Rampion Two Offshore Wind Farm

**Appendix E6 to the Natural England Deadline 6 Submission**

**Natural England's Advice on Fish and Shellfish**

Planning Inspectorate Reference EN010117

Figure 5.17 Predicted Worst Case and Mitigated (DBBC) Behavioural Response Impact Ranges for Sensitive Features from the Piling of Multileg Foundations (135dB SELss)

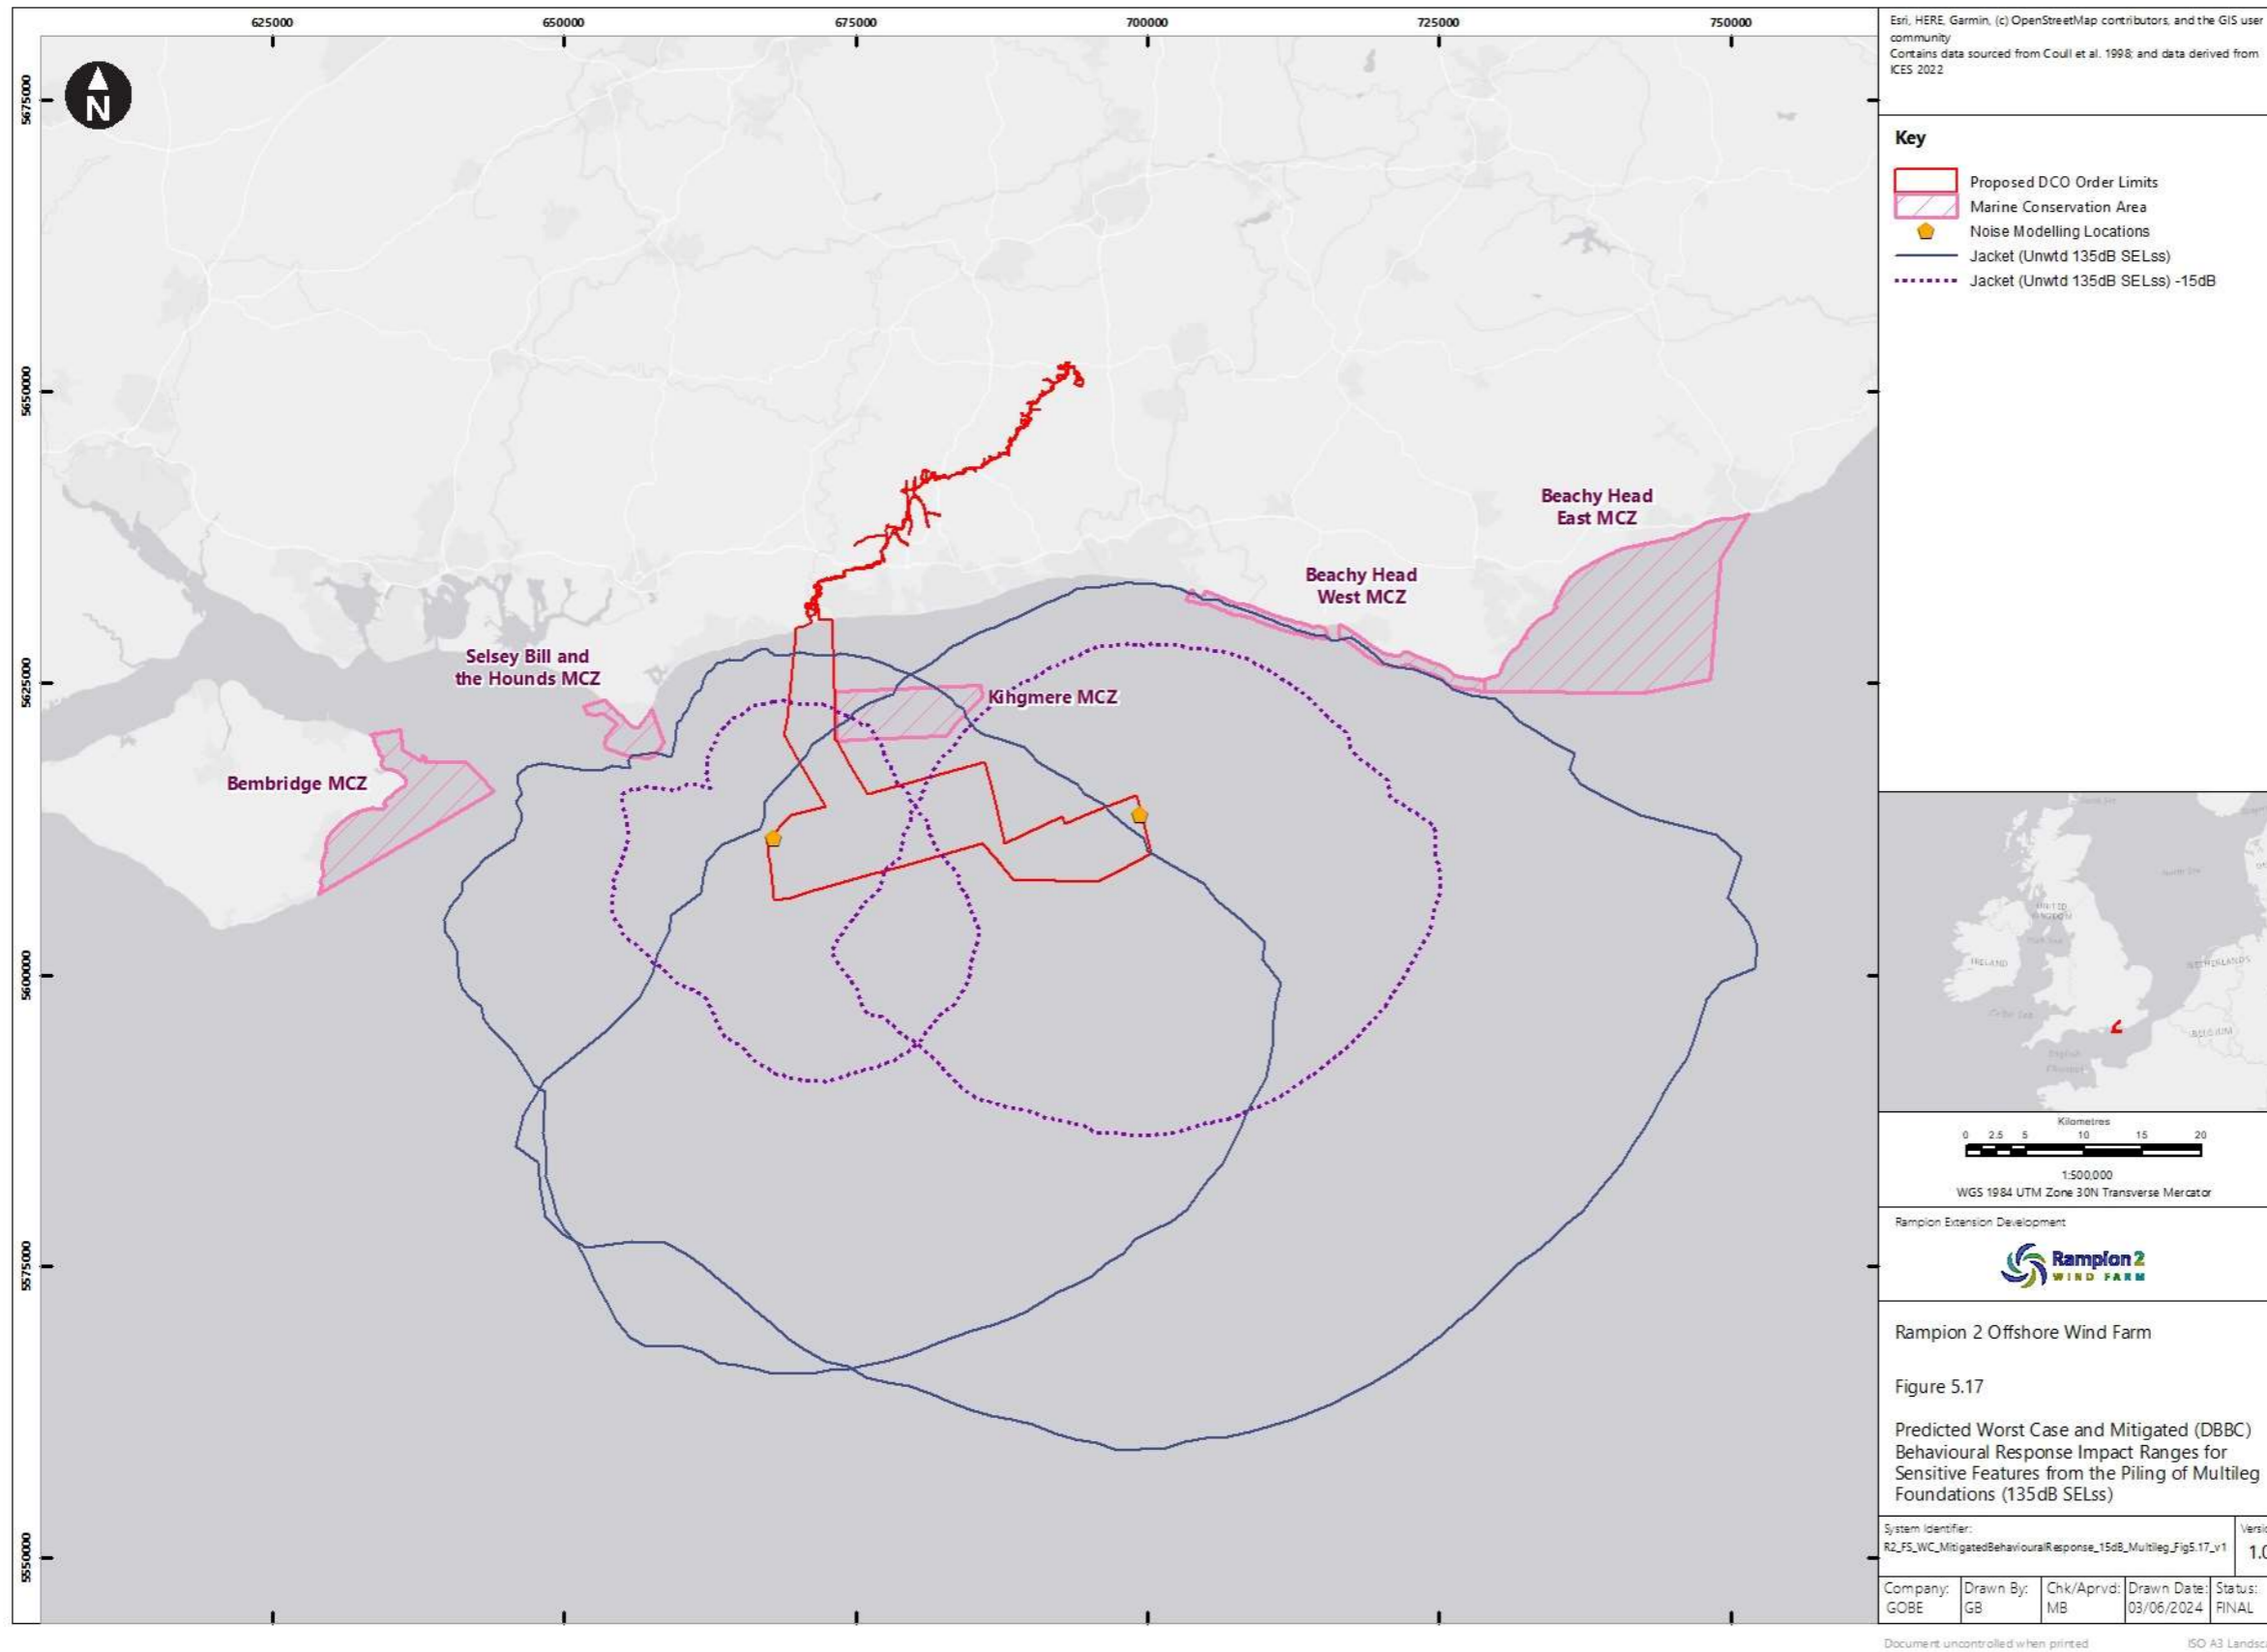
- We note that Figures 3 and 4 are unclear, as the high-level view appears to show overlap with the site at 135dB in both the unmitigated monopile and potentially the multileg scenario (in accordance with Figure 5.5 and Figure 5.6 [REP4-062] submitted at Deadline 4), however the zoomed in insert map does not. Provided the insert is correct then it appears that behavioural impacts from underwater noise on short-snouted seahorses will not be realised within Selsey Bill and the Hounds MCZ. However, we advise that clarity is gained from the Applicant to ensure that the insert is correct.
